Project Name: TORRENTINO SUBDIVISION

**CITY OF ALBUQUERQUE
PLANNING DEPARTMENT
June 22, 2005
DRB Comments**

PROJECT # 1003696 APPLICATION # 05-00998

RE: Lots 26 & 27, Torrentino/minor plat

2005891685
 8887133
 Page: 1 of 1
 66/27/2005 02:10P
 Bk-2805C Pg-222

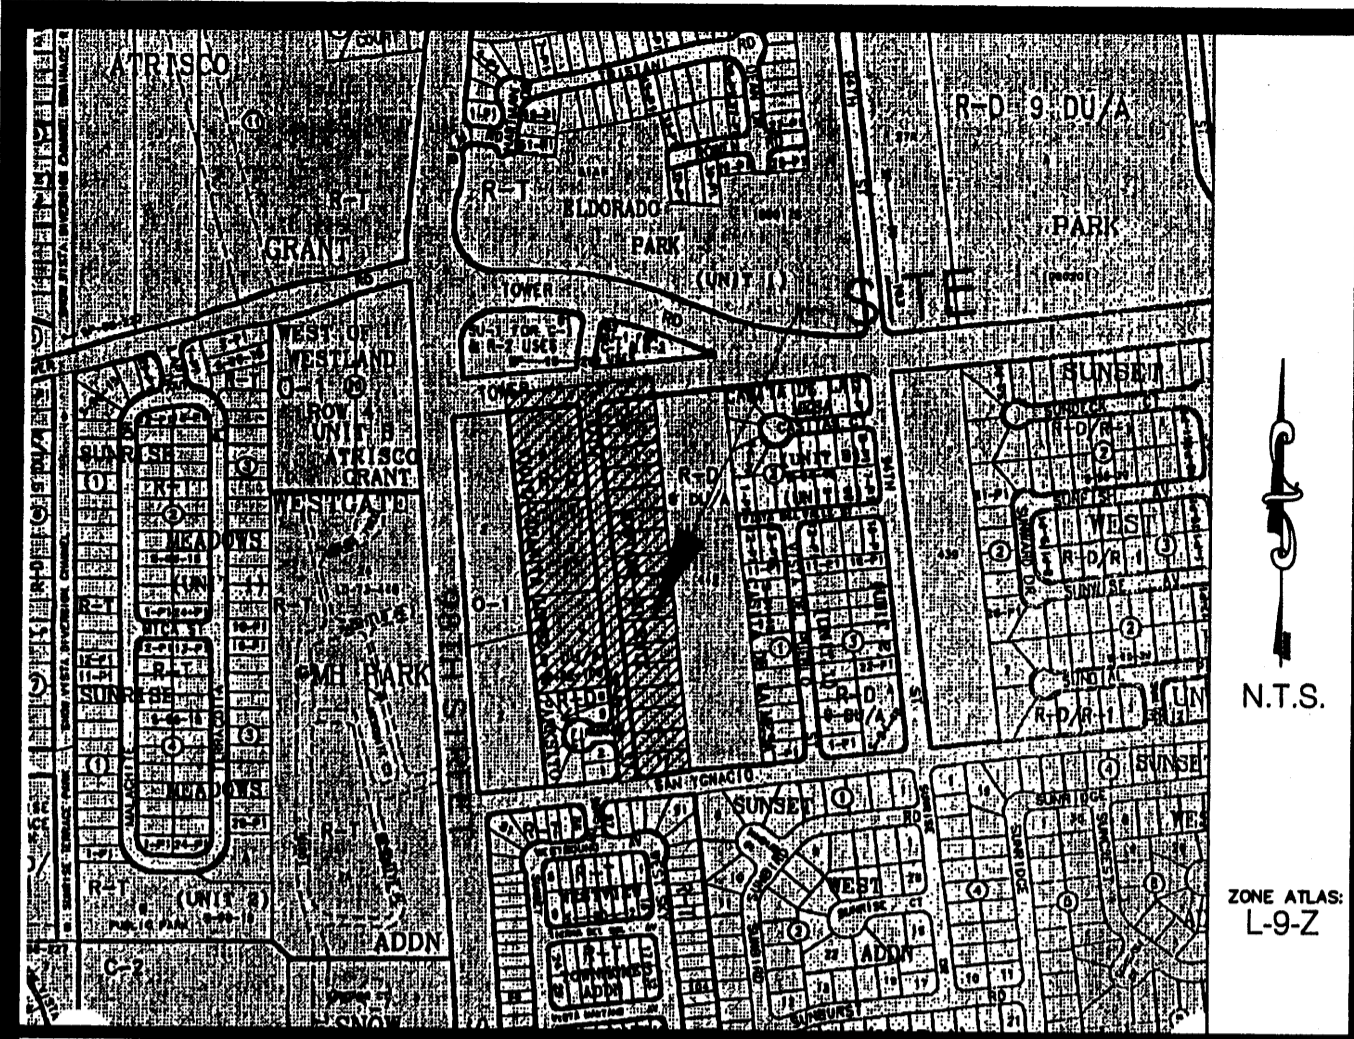
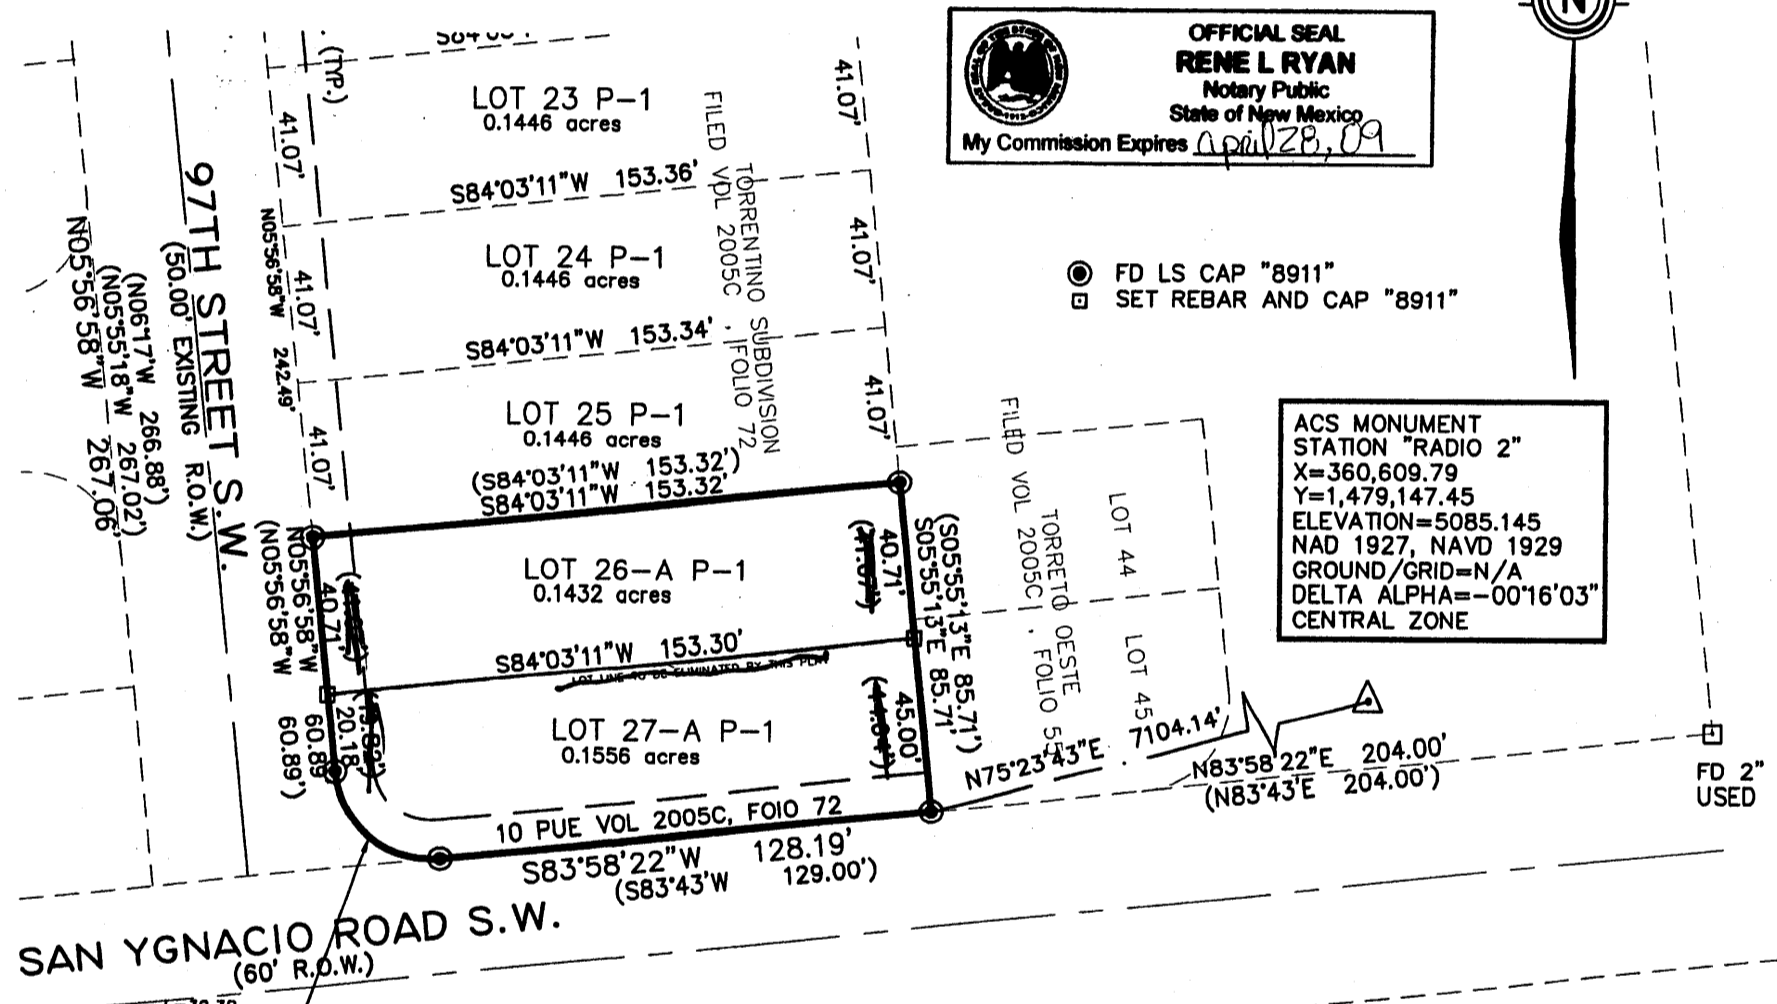
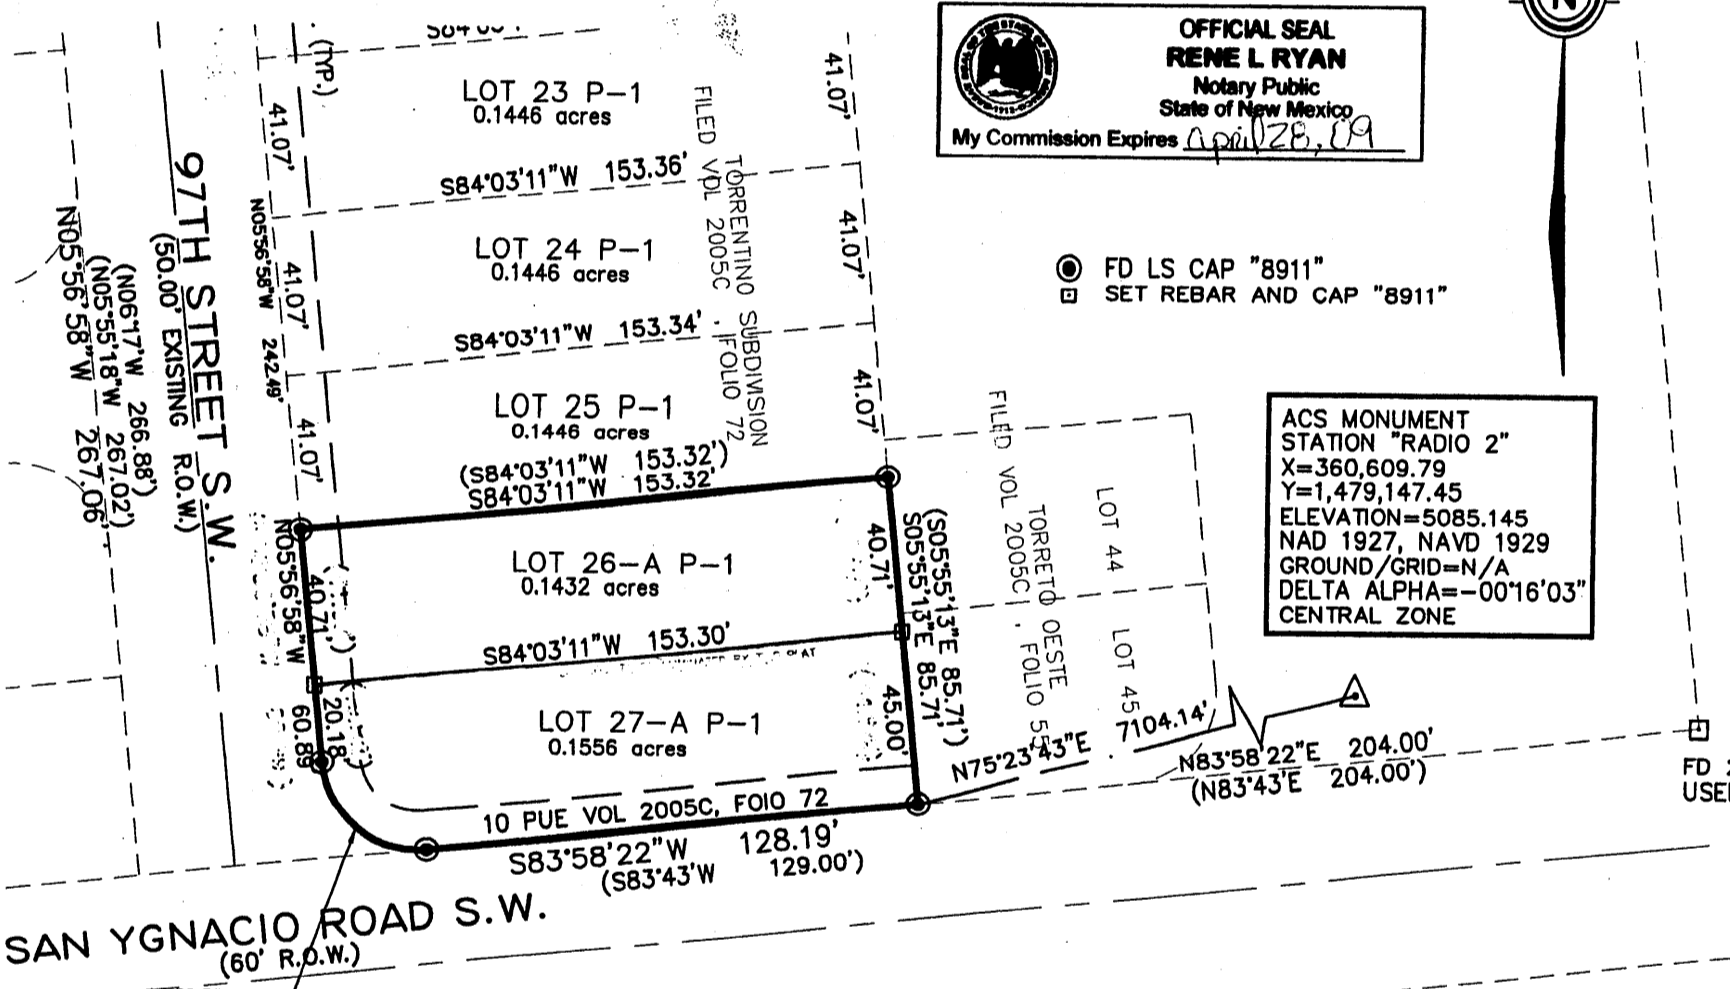
The language on the plat, "Lot line to be eliminated by this plat" should be eliminated because it leaves the impression that the new lot line is the one eliminated by this action.

Instead, the new east/west dimensions on the two affected lots indicate a change in lot line. However, the old dimensions, in parentheses(?) should be taken off as they are also confusing.
